EPC STORMWATER REVIEW COMMENTS
 IN ORANGE BOXES WITH BLACK TEXT

EL PASO COUNTY GRADING AND EROSION CONTROL PLAN CHECKLIST

Drawn by	Log	Checked by	TAK	Date
AS SHOWN		25 of 33		NOVEMBER 2024

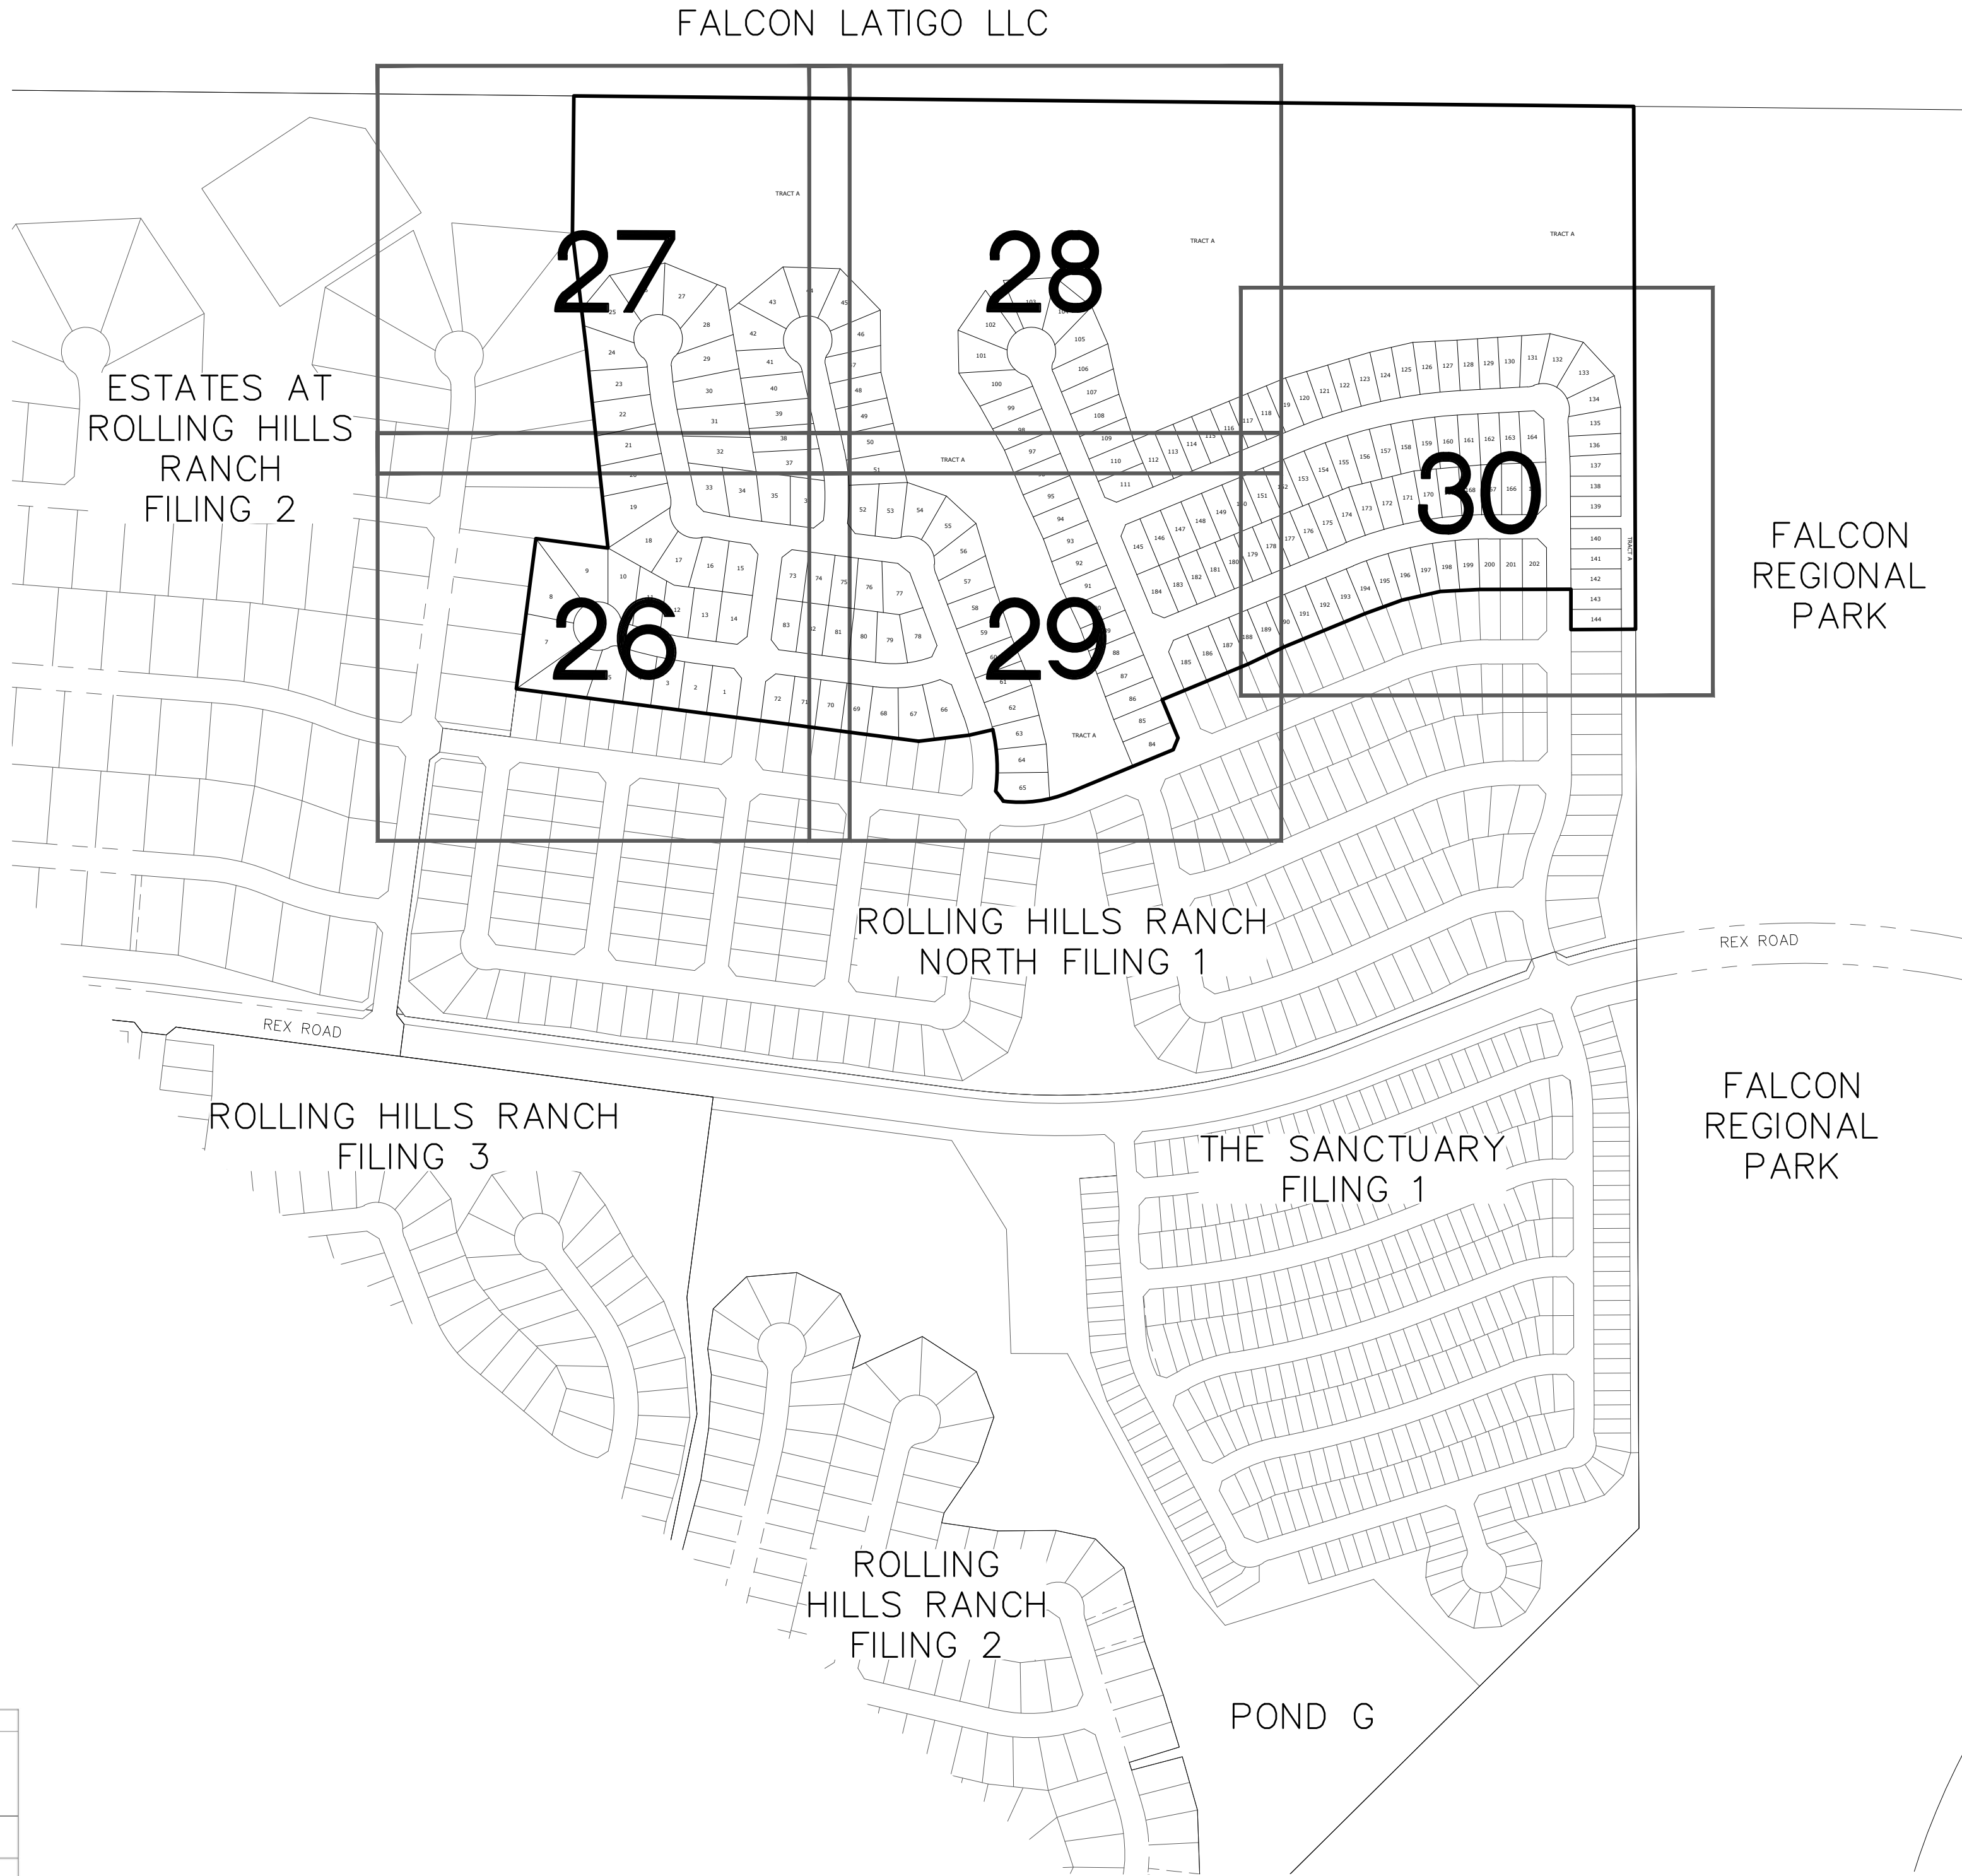
l	Existing and proposed contours 2 feet or less (except for hillside)		Y
m	Limits of disturbance delineating all anticipated areas of soil disturbance		Y
n	Identify and protect areas outside of the construction site boundary with existing fencing, construction fencing or other methods as appropriate		N/A
o	Off-site grading clearly shown and called out		N/A
p	Areas of cut and fill identified		Y
q	Conclusions from soils/geotechnical report and geologic hazards report incorporated in grading design (slopes, embankments, materials, mitigation, etc.)		Y
r	Proposed slopes steeper than 3:1 with top and toe of slope delineated. Erosion control blanketing or other protective covering required		N/A
s	Stormwater flow direction arrows		Y
t	Location of any dedicated asphalt / concrete batch plants		N/A
u	Areas used for staging, storage of building materials, soils (stockpiles) or wastes. The use of construction office trailers requires PCD permitting. Addressed in notes found on Sheet 25		N
